Kirkby Thore Parish Council [KTPC] thanks National Highways [NH] for the production of the 6 Engineering Sections through the works contained in the document REP5-025. These make it much easier to see the physical size and effect of the acoustic bunding around the village. It would have been helpful if the levels for the crests of the bunds had been noted in the same way as the levels of the carriageway as our comments below would have been able to reference these levels rather than those that we have scaled for the sections.

We comment on each section as follows:

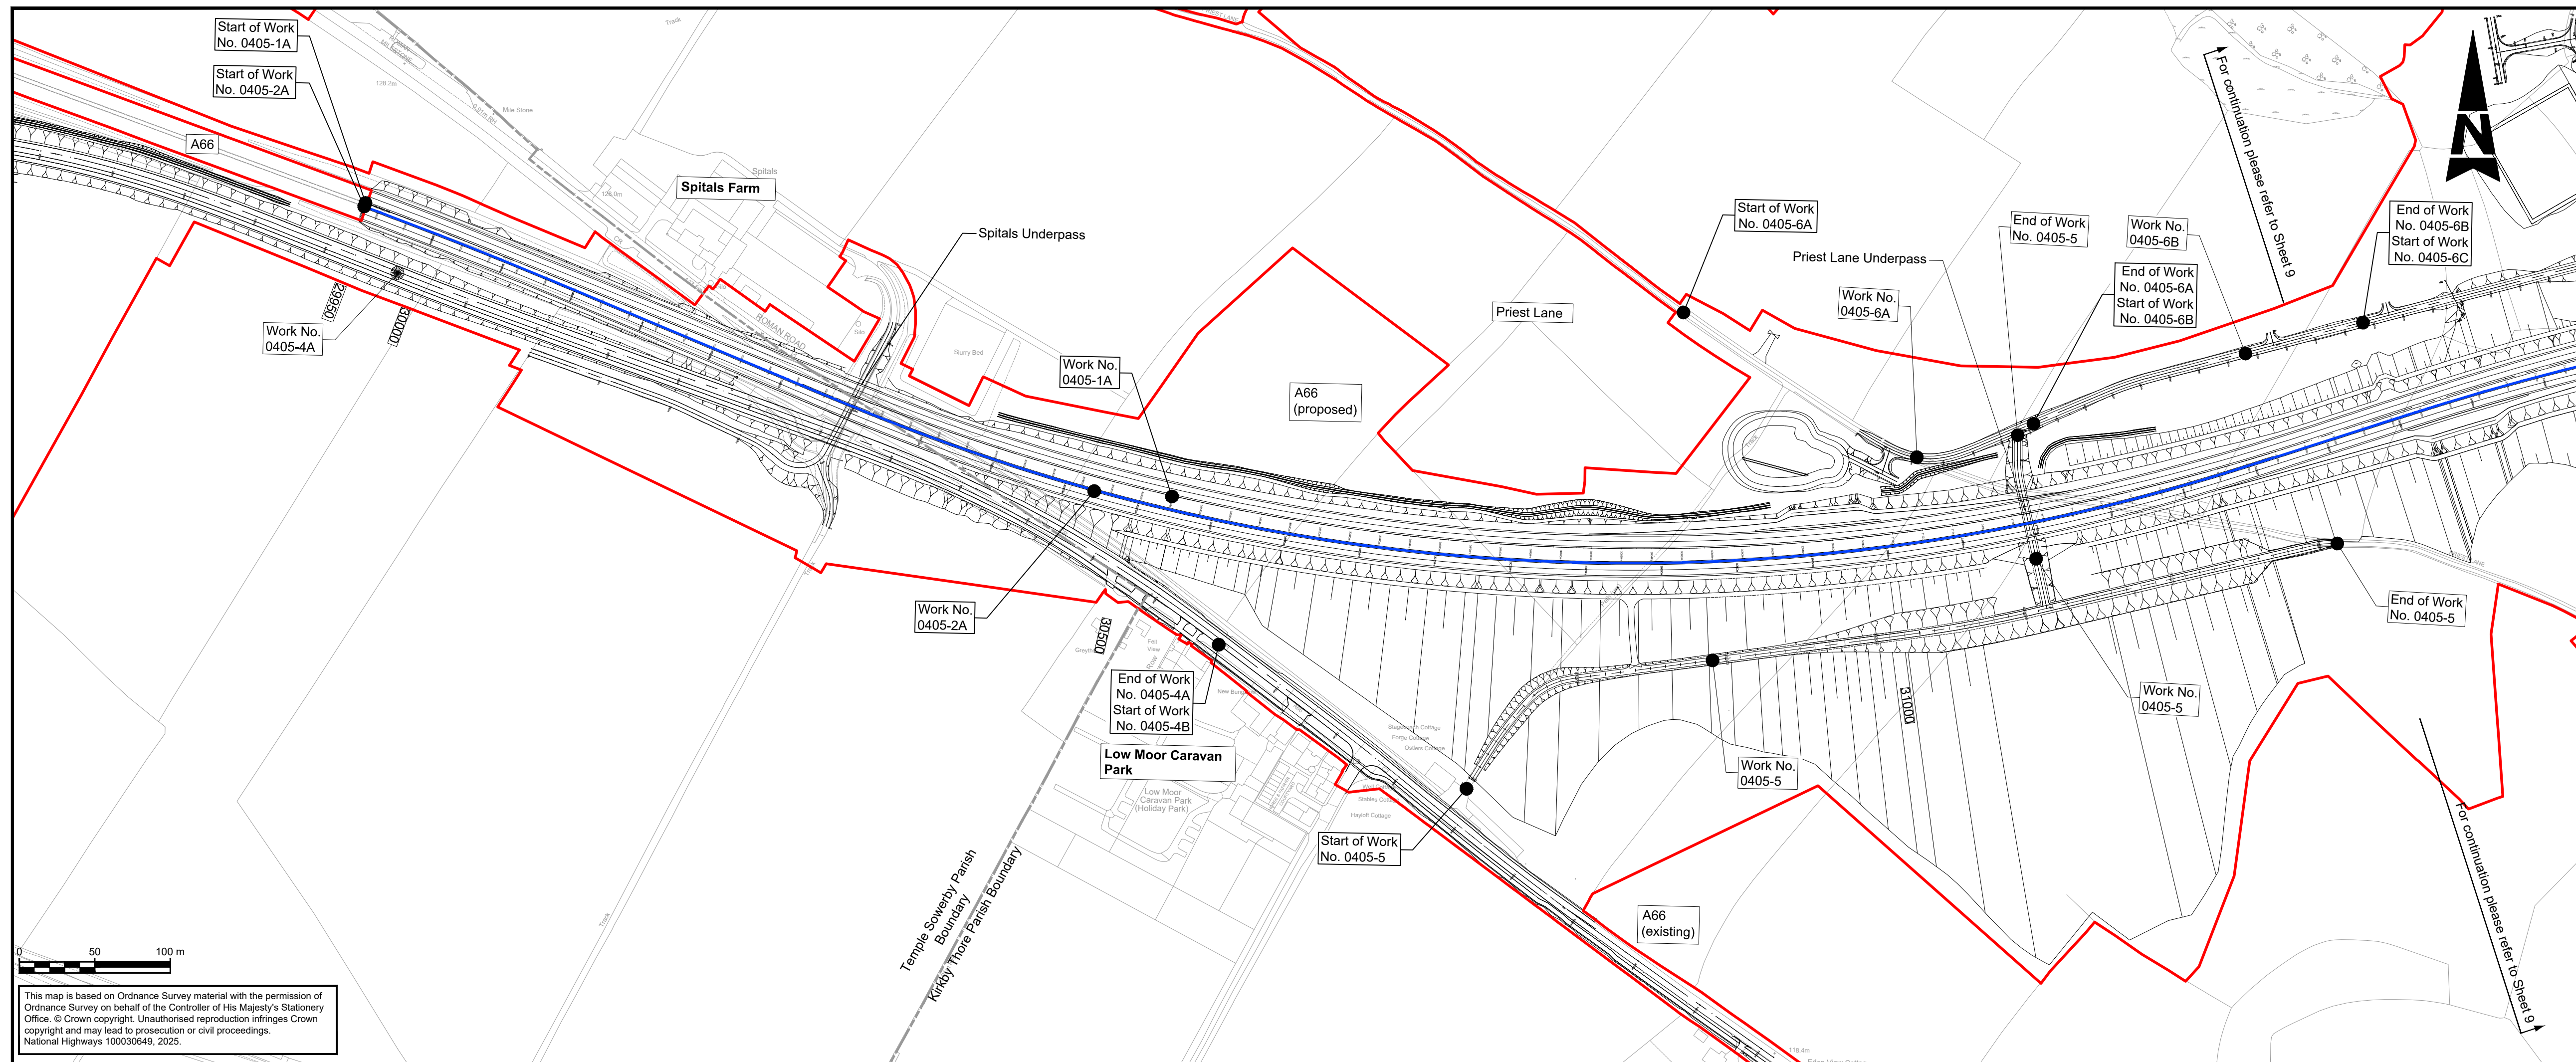
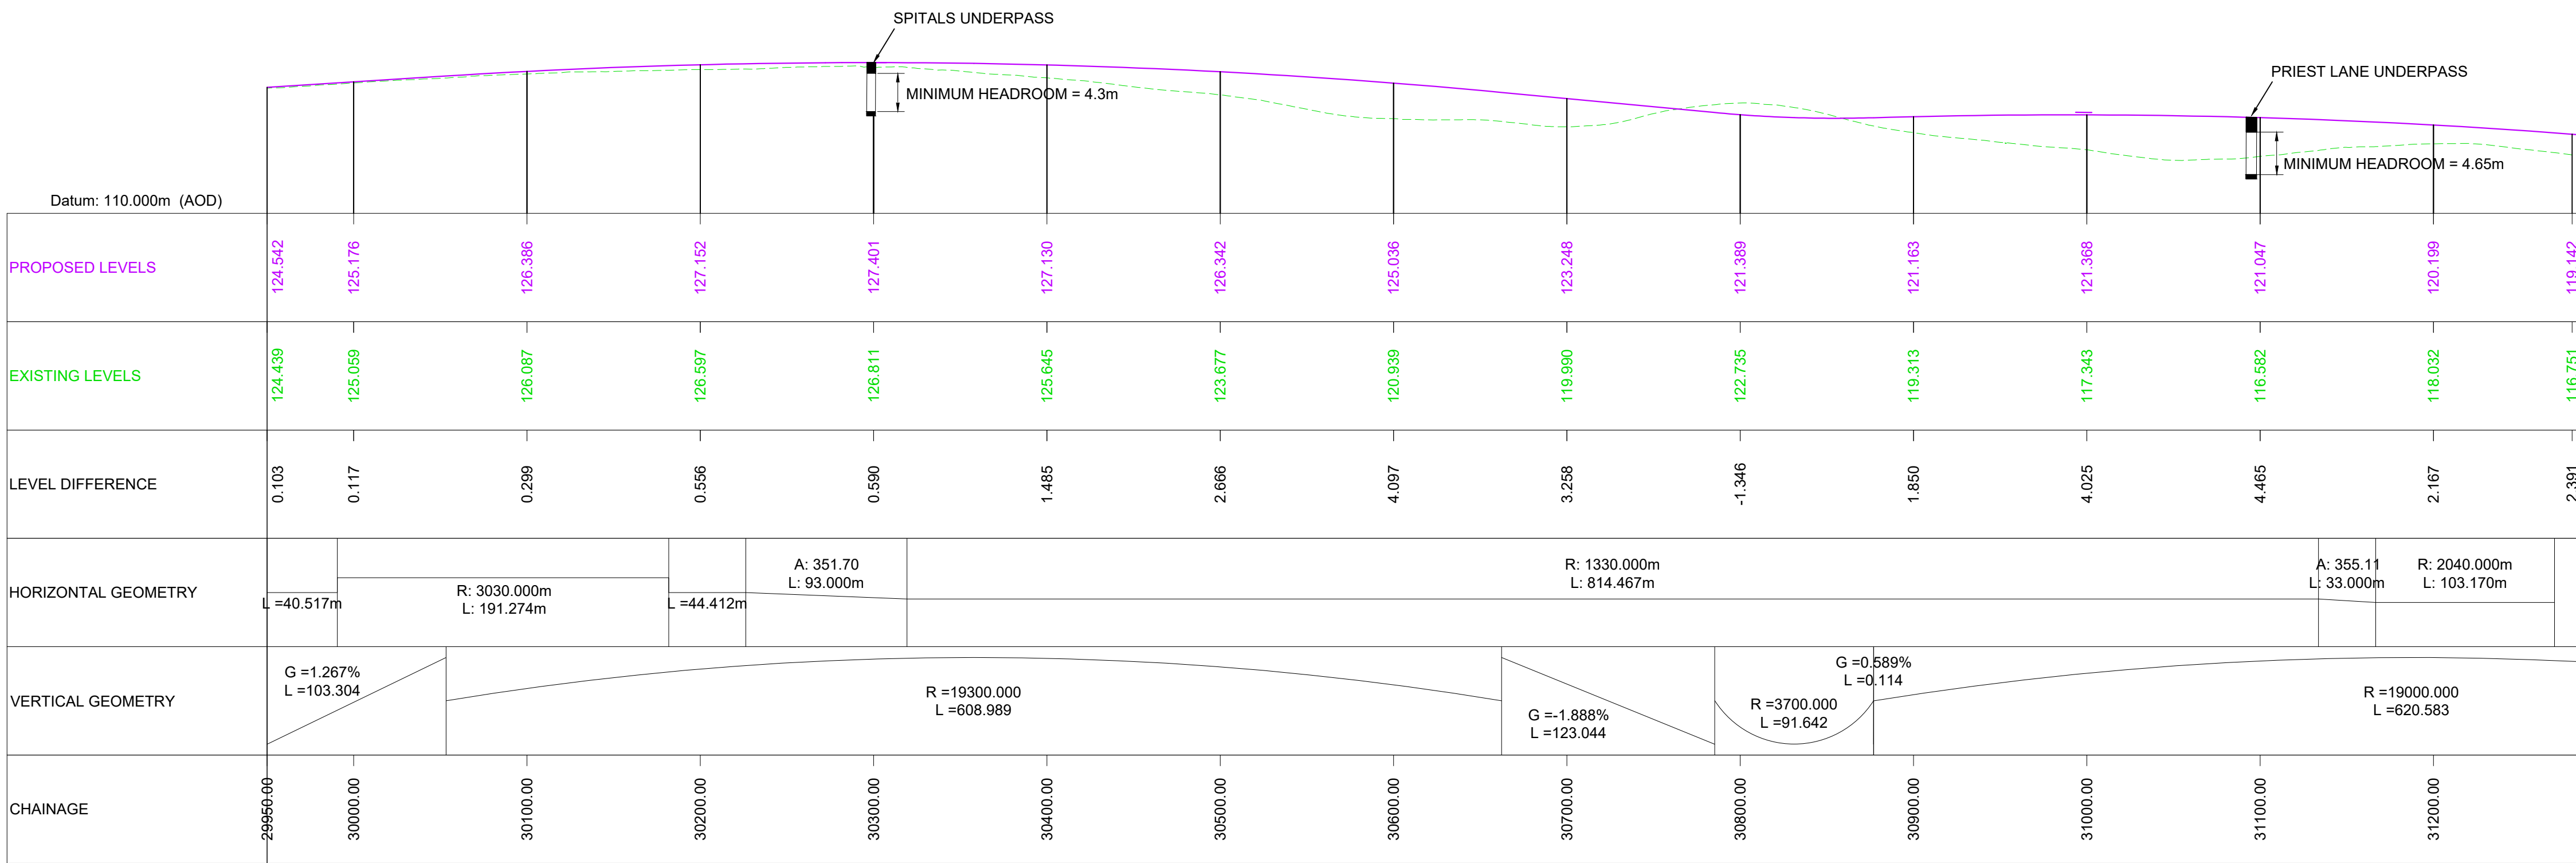
Section 1- from Dunfell View looking north-easterly. The ground level at Dunfell View is shown as 119.5mOD at the Order Limit but we believe that the ground continues to rise beyond this. And we also note that the first floor of the houses would be 3m above that [at least 122.5mOD]. However, the bund between Dunfell View and the A66 is shown as approximately 127mOD with the carriageway noted at 117.14mOD thus the visual and acoustic screen appears to be adequate for this direction.

Section 2 – Priest Lane junction with Dunfell View looking westerly along Priest Lane. Priest Lane runs for about 150m at 120mOD before dropping then rising to the bridle way and then the A66, which are both at 120.3mOD. The bund before the A66 has a crest of about 123mOD so HGVs, being between 4 and 5m tall, would be visible to the bungalows at the western edge of Dunfell View. Tree planting on the eastern slope of the bund would provide visual screening to these dwellings and to the bridleway as it passes close to the A66.

Section 3 – Existing A66 to Sleastonhow Lane. The A66 is at 117.82mOD, some 9 metres above the Trout Beck flood plain, and in only 1 metre of cut. There is no bunding. The ground rises to the north-east up to the bungalow and farm of Sleastonhow 200m away at 133mOD. There is no bunding or other acoustic or visual protection for these dwellings. We believe that there will be significant impact on Sleastonhow and that mitigation for noise and visual impact is required.

Section 4 – From Sandersons Croft through the compact grade separated junction. The ground at Sandersons Croft is at 125mOD, thus the first floors of the houses are at 128mOD. The slip road of the junction is 83m away at 123mOD. There is a bund crest of about 127mOD between the road and Sanderson's Croft. Hence at this section the bund appears to be 4m which is not adequate to screen all HGVs in the UK and the slip road will continue to rise to ground level at the existing Fell Lane thus the bunding of 4m will not continue along the full length. The A66 is in at least 4m cut at this section but the slip road to the north of the junction, at 322m away, is at existing ground level, which is 128.37mOD. Thus, this northern slip road has no screening for Sanderson's Croft.

We believe that the screening for Sanderson's Croft is inadequate and further mitigation measures should be taken.

Section 5 – from Priest Lane junction with Dunfell View looking in a north-westerly direction. The ground level at the junction is 120mOD. The road at this section is at 114.6mOD and has a screening bund with a crest of 121mOD. Hence the cut is 6.4m and adequate to screen all traffic.

Section 6 – From Kirkby Thore School looking in a north-westerly direction. The ground level at the school is 116mOD and the ground drops towards the north-westerly school playing field boundary 120m away at 112.6mOD. The A66 is a further 90m beyond the school boundary at level 113.17mOD. There is a bund with crest level 116mOD between the road and the school thus the road is only in effective cut of 3m, which is not adequate to screen HGVs, additionally the top of the bund is at the same level as the school buildings. Further to the north-west of the road there is an embankment to 120.36mOD that is carrying the diverted Priest Lane.

Hence for the length of the A66 behind the school we do not believe that there is adequate screening and further mitigation measures are required. As the Priest Lane embankment already blocks the views to the north then higher embankments and/or a block planting of trees on the school side of the road would not provide any adverse impact and would significantly benefit the school.

We also note that the first floors at Dunfell View at 123mOd will overlook the school and have a direct sight/noise line to the A66 at this section so additional mitigation will also benefit Dunfell View.
